WSA Reference: WSA25.009

1953-2109 Elizabeth Drive, Badgerys Creek

SSD70818708

Thank you for the opportunity to comment on the State Significant Development Application (SSD70818708) for the southern portion (Stage 1) of the DHL Logistic Facility, located at 1953-2109 Elizabeth Drive, Badgerys Creek. We understand that the proposal comprises:

Drawing Name
Material and Plant Schedule

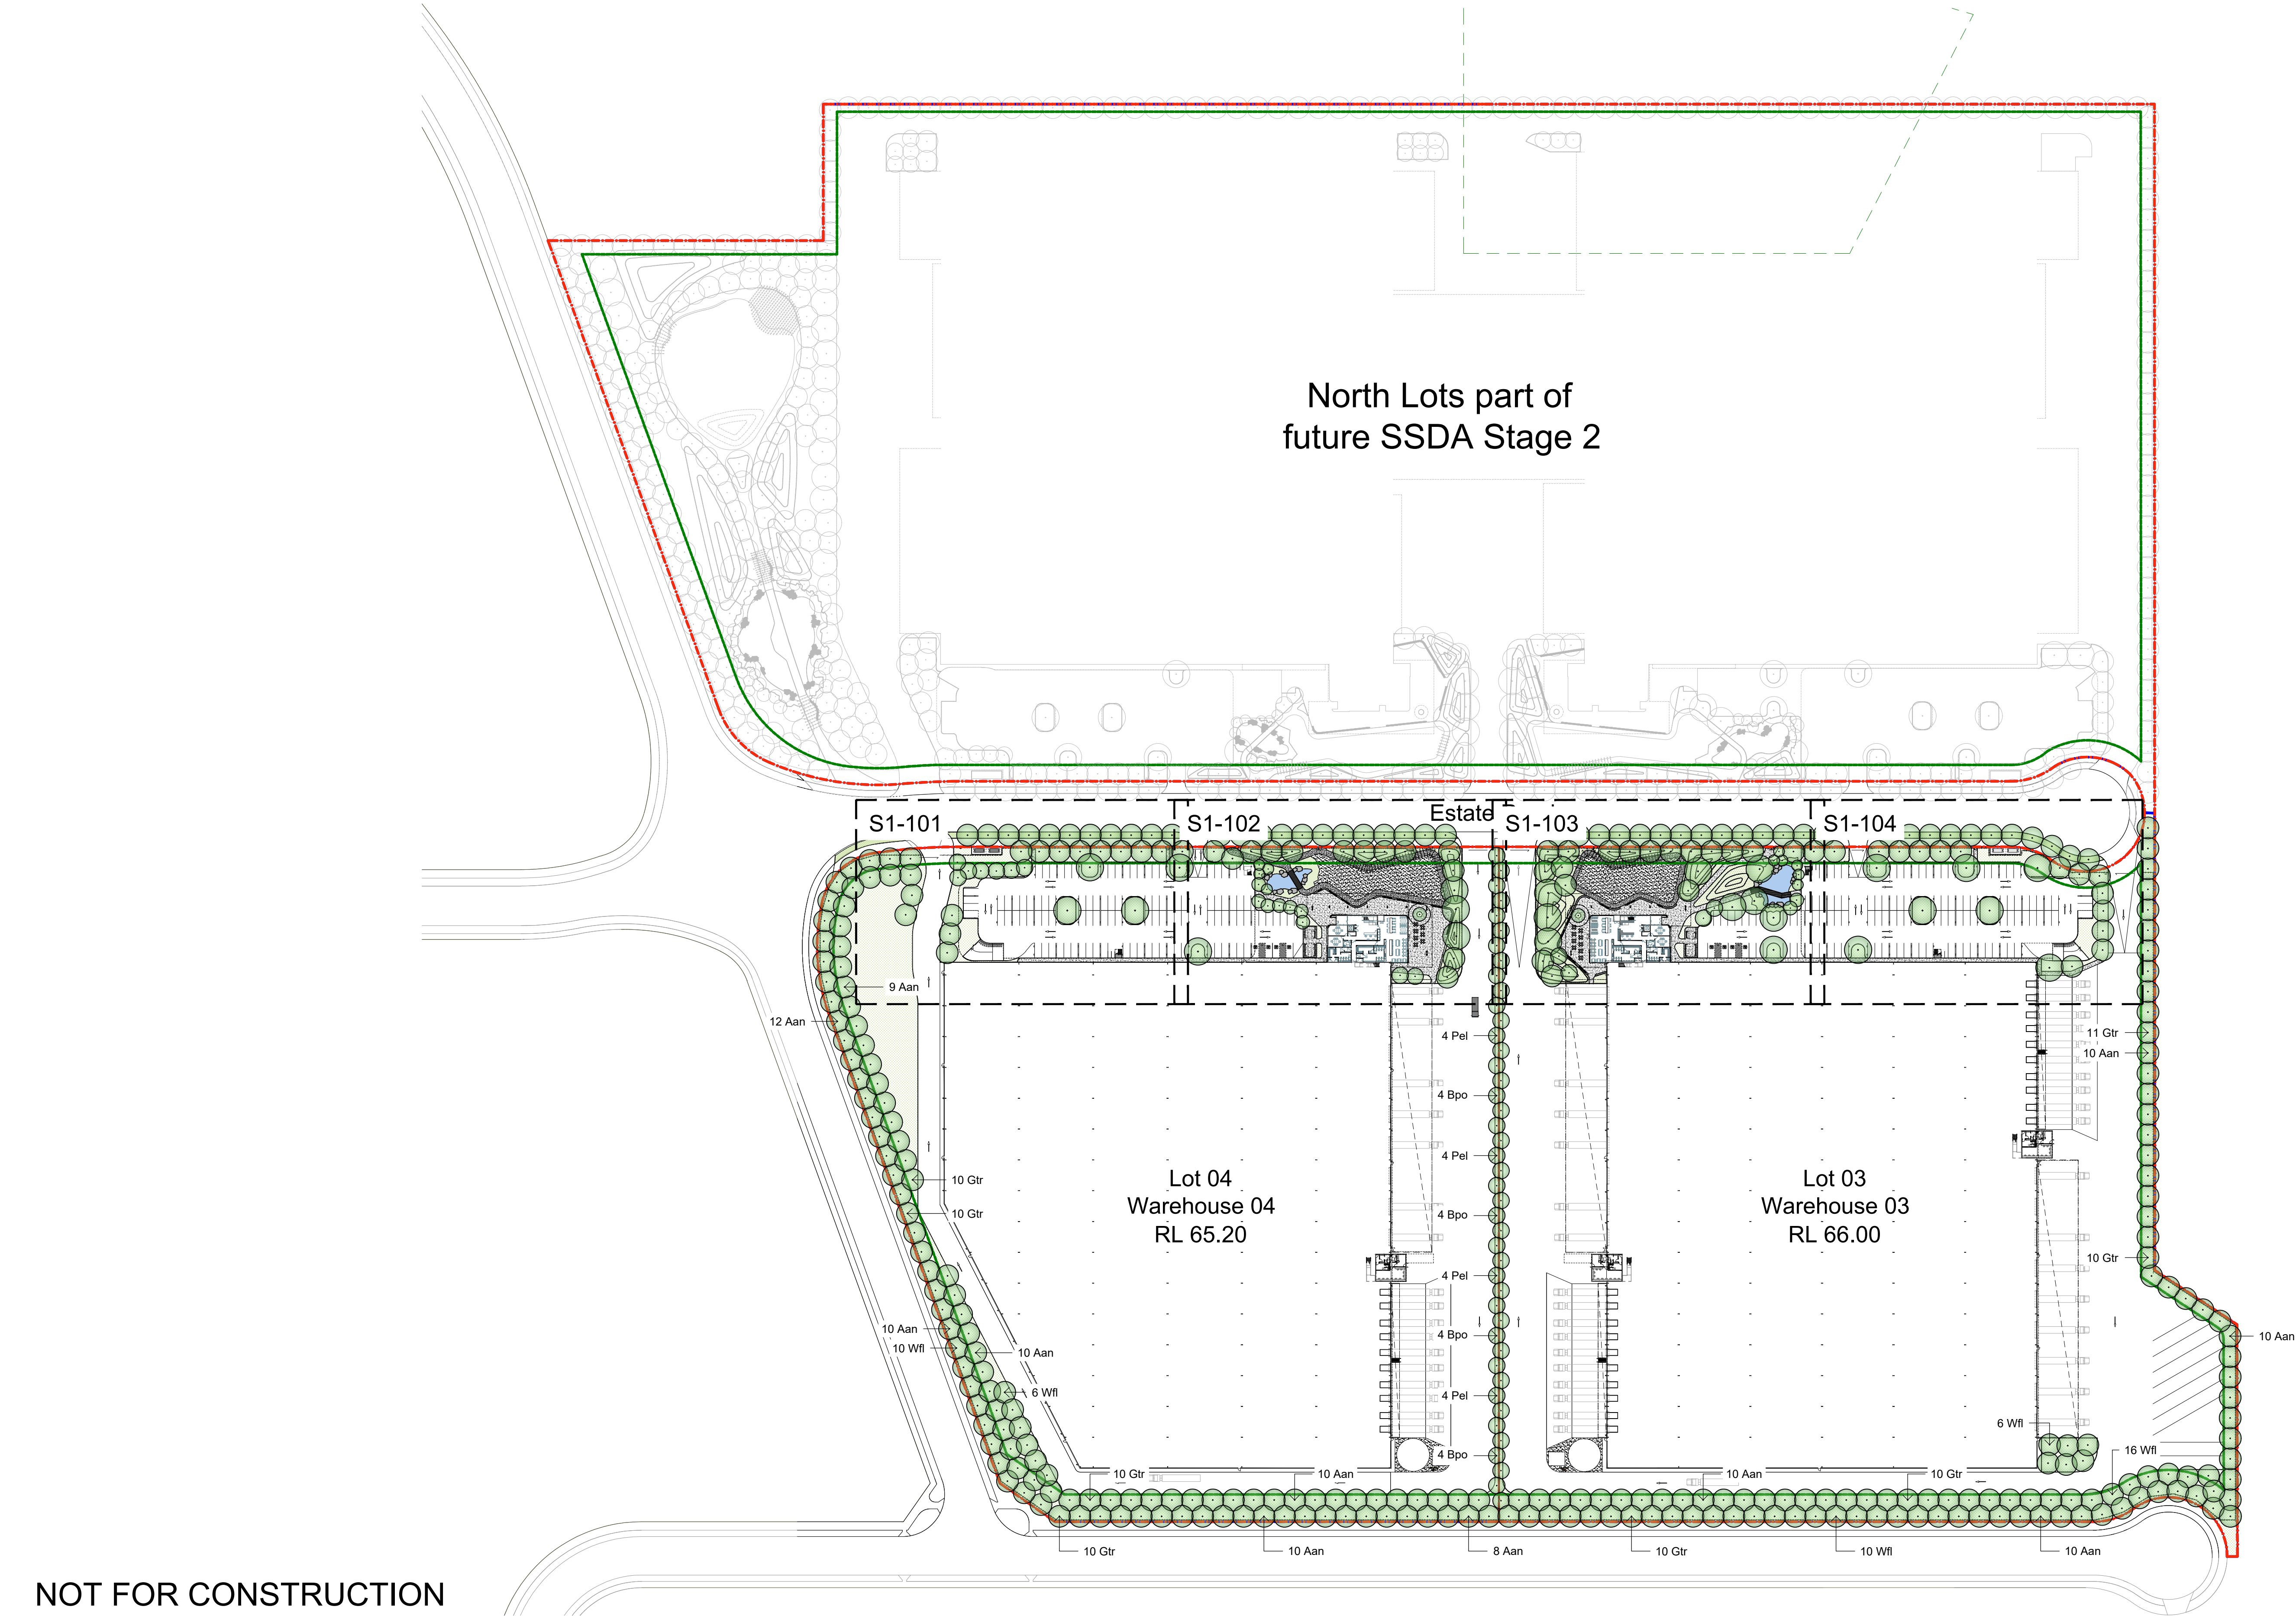
Wildlife Hazards	
Development is within the wildlife buffers, and proposes features	It is not clear if the Landscape Species selected is in accordance with the Aerotropolis Development Control Plan Appendix B Western Sydney Aerotropolis Landscape Species List. Confirmation is required that the appropriate landscape species

which could attract wildlife	are being used to ensure that wildlife attraction risk is adequately addressed. Of note, the EIS indicates that the Aviation Impact Assessment (AIA) addressed suitable landscape species to demonstrate that wildlife attraction is mitigated. The AIA did not address this.
	Given the site location in relation to future flight paths and the extent of landscaping and bioretention basins, the proposed development should address the following to minimise wildlife attraction: • Design, management and monitoring of the onsite bio retention and sediment basins. • Landscaping species selection and maintenance. • The design and management of waste storage areas/receptacles during construction. • External handling and storage of organic materials. • Monitoring and management of any wildlife.
	Whilst a Biodiversity Assessment was undertaken, there is no assessment as to the potential impacts of any wildlife on that site and impact to airport operations. Given there are basins on site, this should be undertaken, particularly in relation to ongoing management and mitigation and the sites proximity to arrival and departure flight paths, where aircraft will be operating at lower altitudes.
